Please ask for: Nicola Moore
Email: nicola.moore@arun.gov.uk
Telephone: Ext 37944
Our Ref: FG/31/22/CLP
Your Ref:
Date: 25th February 2022

Lawful Development Certificate for a Proposed Use or Development

Development: Lawful development certificate for a proposed single storey rear extension.
Location: 12 Highdown Close Ferring BN12 6PJ

B	1:500 Scale adjusted	Feb 2022
Revisions	A Dimensions added	Date Feb 2022
Client	Mrs. S. Clarke	
Project	12. Highdown Close Ferring BN12 6PJ	
Title	Proposed site and location plan	
Scale 1:500	Date Sept 2021	Drawn KEL
Paper Size A3	Doc No 005

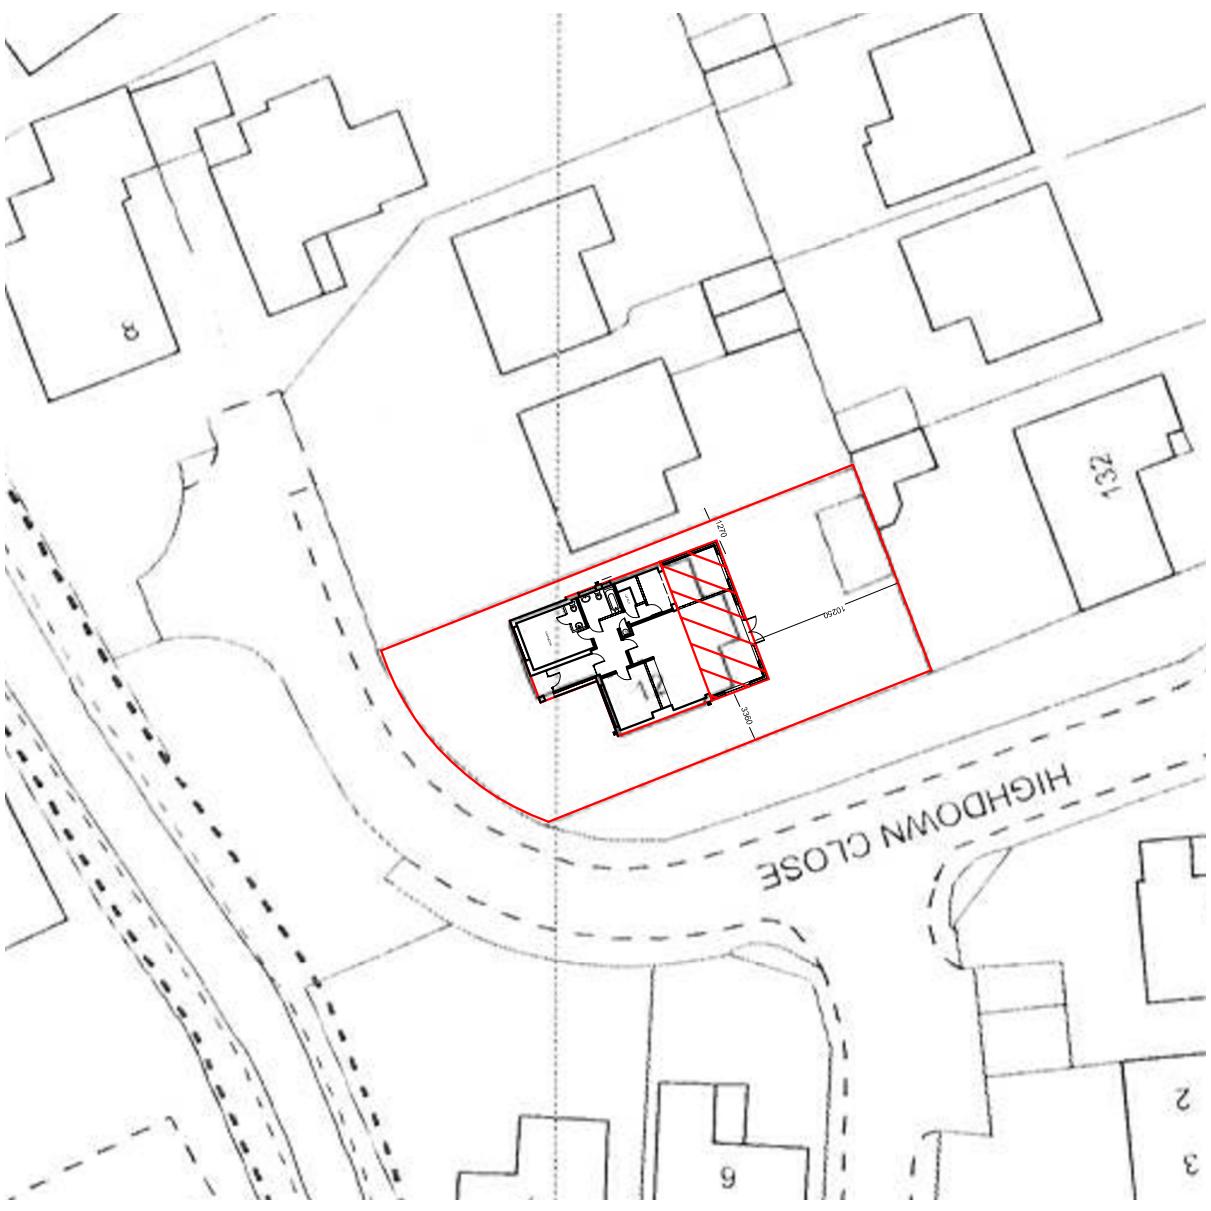
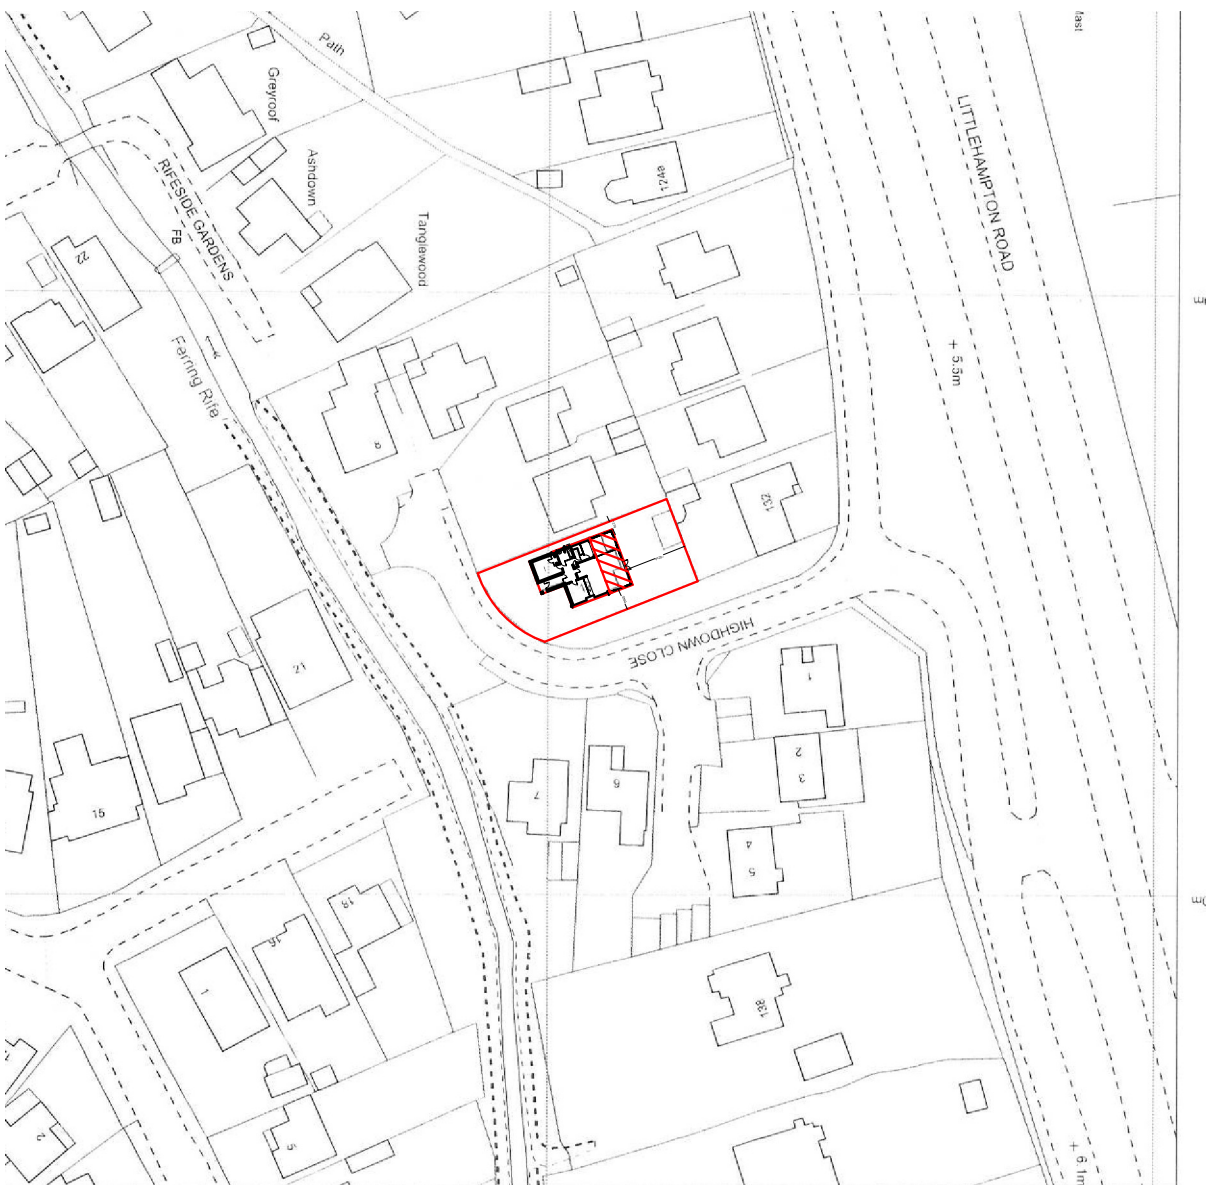
Block Plan

The Block Plan should include distances to boundaries from the proposed development. Please amend accordingly and re submit. Further details of what must be included on the plan can be found in the Validation Requirements List.
